From: Zac Denton
Sent: 11 April 2019 15:13
To: Planning.Responses
Subject: FW: AB/14/19/HH & AB/15/19/L

AB/14/19/HH & AB/15/19/L

This application relates to a two storey extension, single storey rear extension and external staircase.

MPS		PROPOSED ELEVATIONS AND SECTIONS	14/01/19	A
DRAWN	CHECKED		DATE	REV

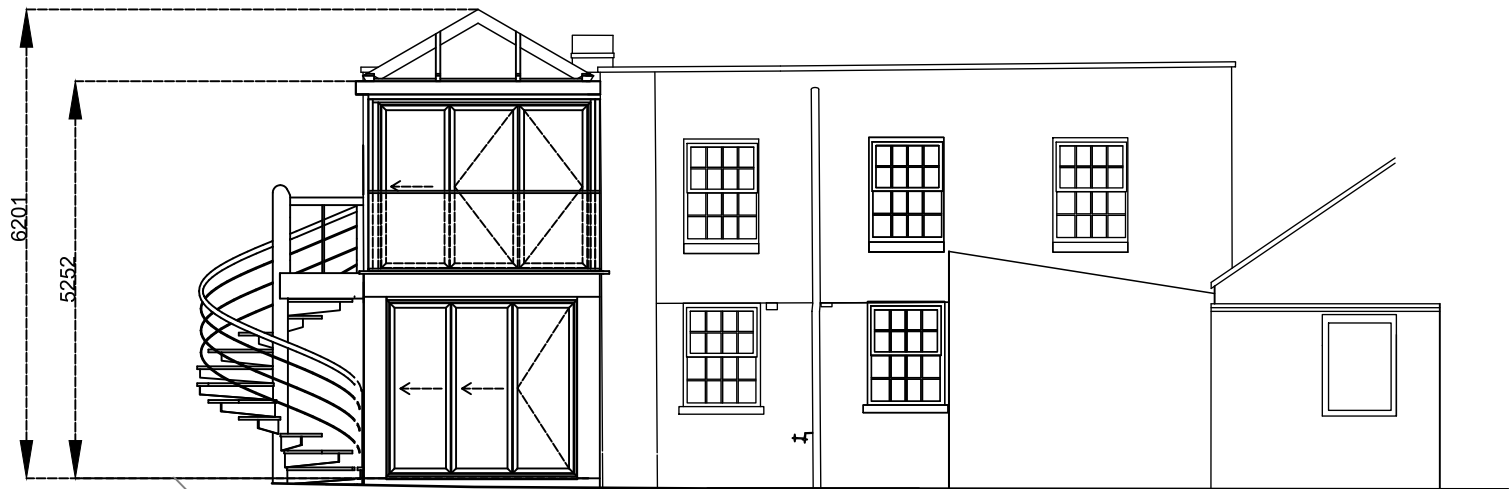
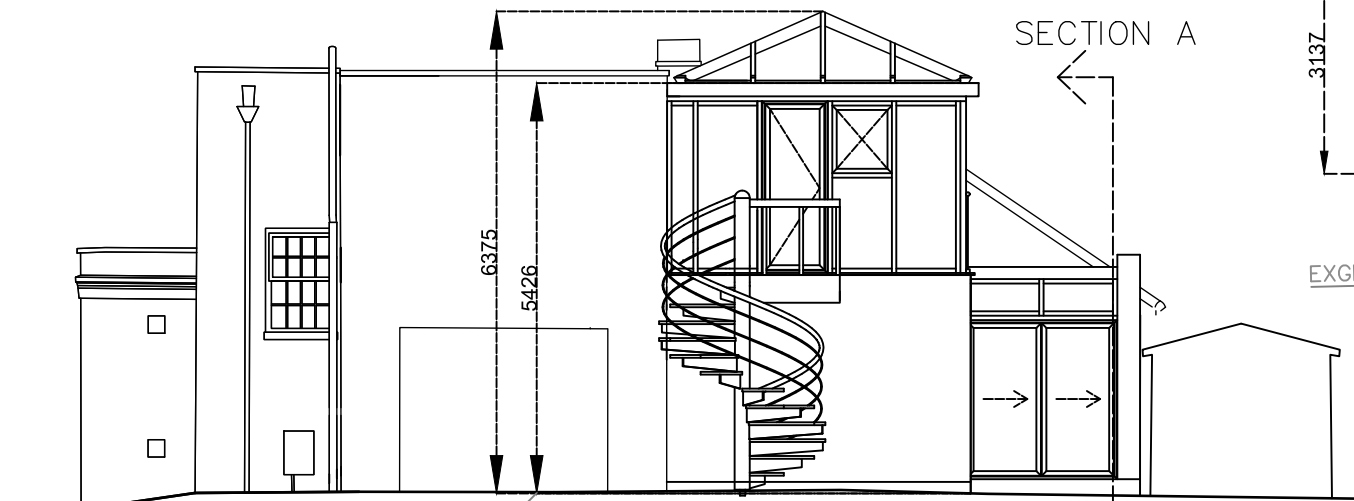
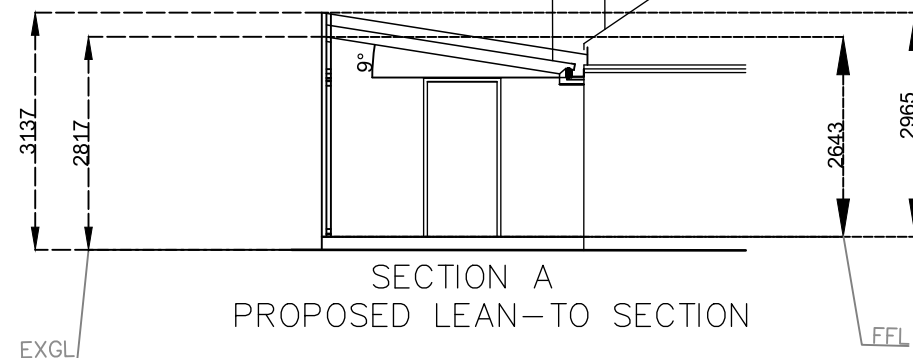
The single storey element of the proposal is closest to the Tower House and number 1 London Road, but would be located so as to not be visible from highway, or extensively from the neighbouring private road. It would be attached to an existing single storey structure, which would reduce its impact on the neighbouring listed building. The simple form of the building appears to be acceptable, but the concept of a fully glazed roof could be problematical with regards to light pollution etc.

For the two storey extension, it is not clear how the current proposal has been based on the established characteristics of the local area. The current plans appear as if a standard conservatory has been placed on the first floor of the building, with no consideration given to the context.

Such a structure is not found in such a prominent location. It is noted that the dwelling appears to have a flat roof when viewed from the street, whilst the proposal has a pitch.

There would also be a significant amount of glazing/substantial framing which would allow the interior of the new rooms to be visible from the surrounding area. This is in conflict with the character and appearance of those properties in the local area, and not capable of support in its current form. There could also potentially be issues with light pollution.

It is considered that the conservatory element looks visually cluttered, and therefore out of character with the host dwelling, and the character and appearance of the conservation area.
